SETTLERS VIEW

PRELIMINARY GRADING & EROSION CONTROL PLAN

Add: PCD File No.: SP-17-006

SHEET: **D1.1**

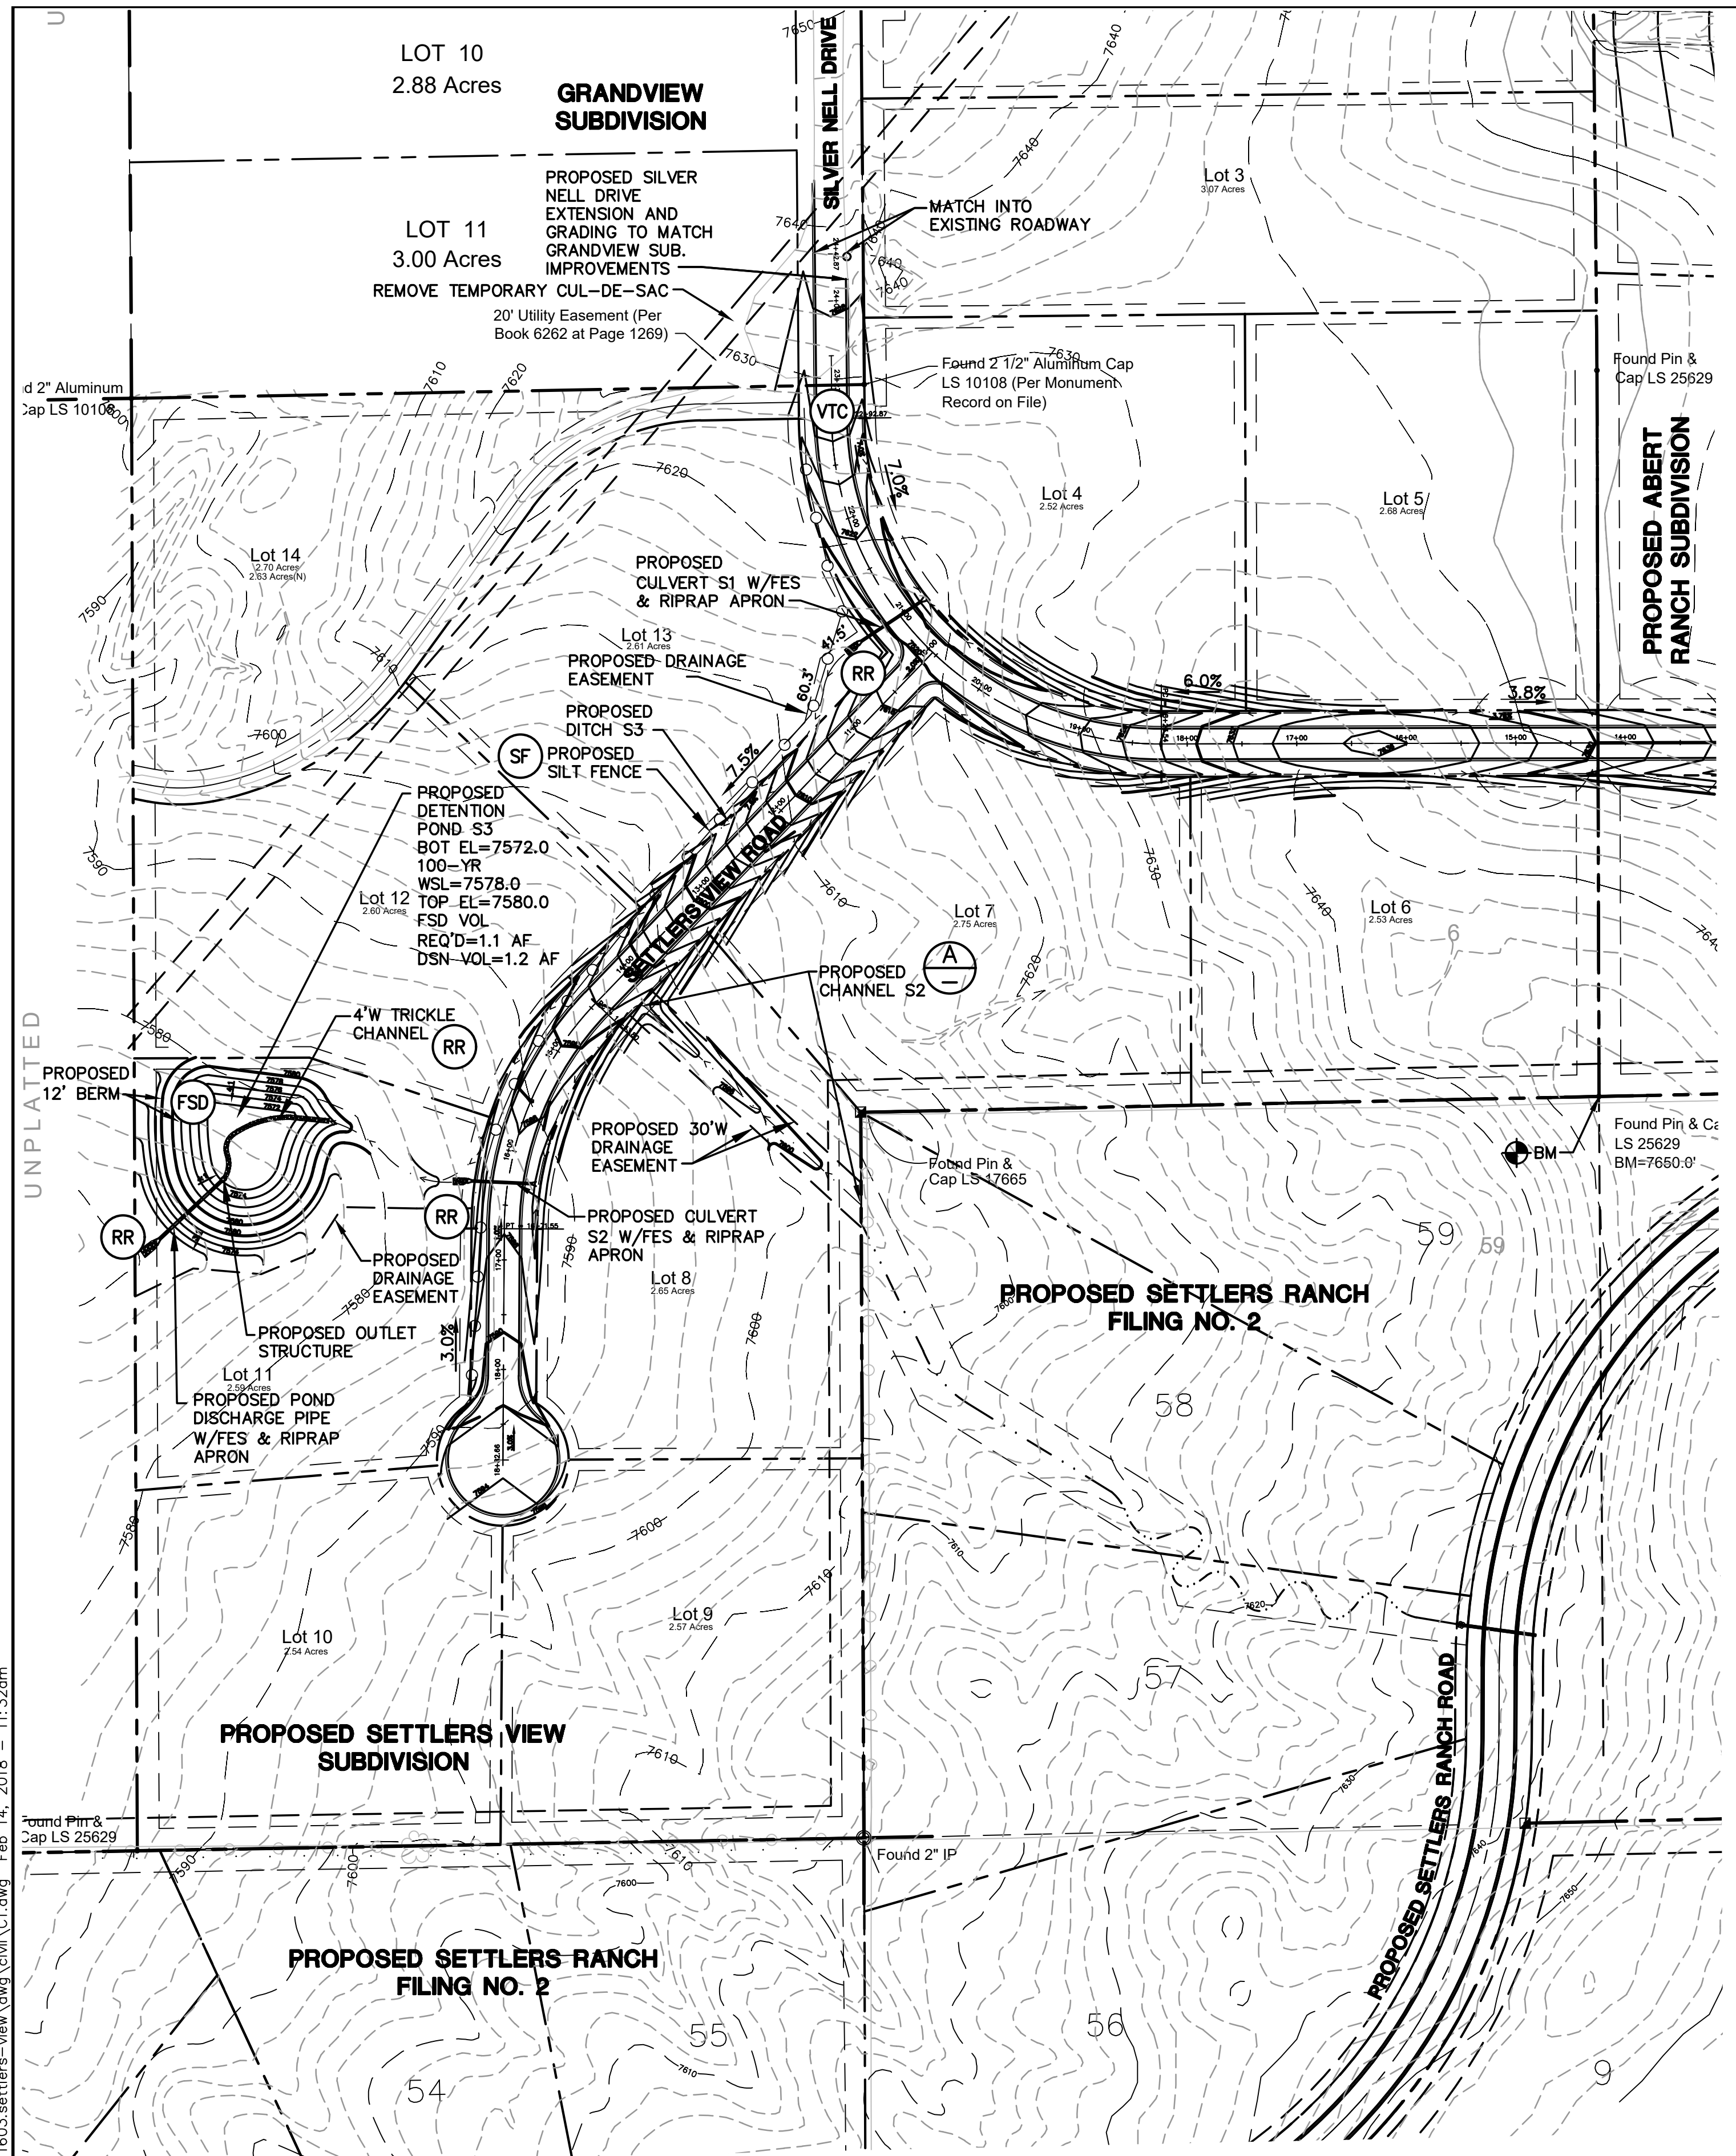
Label the permanent pond easement.

Extend improvement to include the conversion from a temp cul-de-sac to standard cross section. Coordinate with the lot owner.

Add Vehicle Tracking Control

Provide a ditch along the proposed road. (typ)

Concentrated flows from the culvert does not seem to be directed to a roadside ditch. Provide a drainage easement for the flow path. Is the design intent to have both the natural swale and a roadside ditch running parallel since the drainage noted proposed ditch along the west side?
